RFI, Q9 – EIAR, Chapter 4, Human Beings

ACP- 323358-25

Plate 4.2: Dwelling Location Map

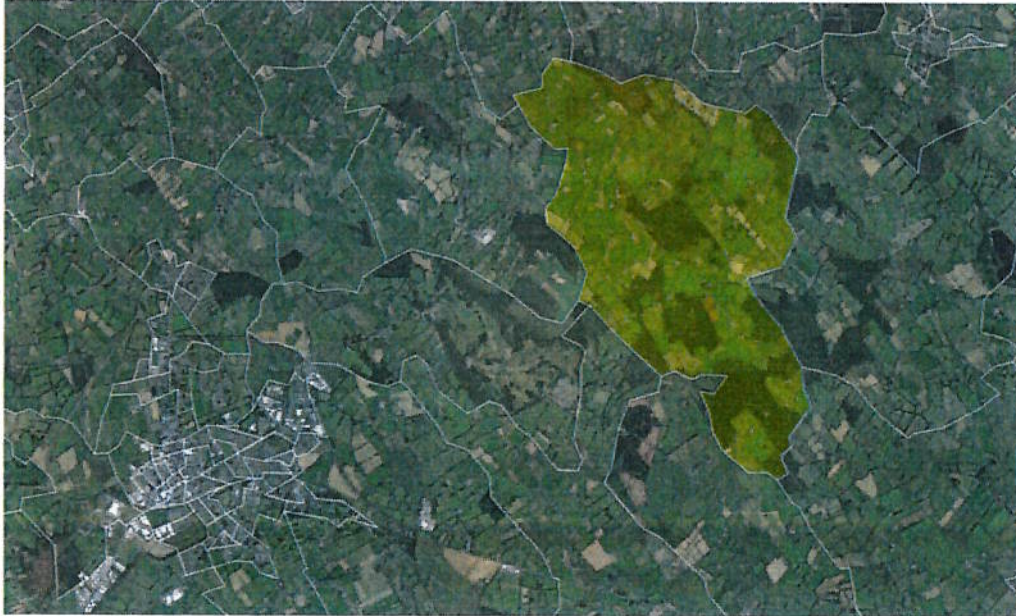
In respect of the EIAR and impacts upon Human Health it is noted and identified that a number of submissions referenced an incomplete assessment of nearby and neighbouring residential dwellings. The applicants are requested to review this section of the report and to identify all known residential dwellings within the vicinity of the proposed quarry and to assess the impact on the same.

The assessment shall include a review of all the private wells and seek to gain access in order to assess the wells within the area and their risk of impacts from the proposed development.

In response to this question an assessment of all nearby and neighbouring residential dwellings was carried out and an up-to-date aerial photograph showing the location of houses in close proximity to the proposed development are shown on the figure 9.1 below.
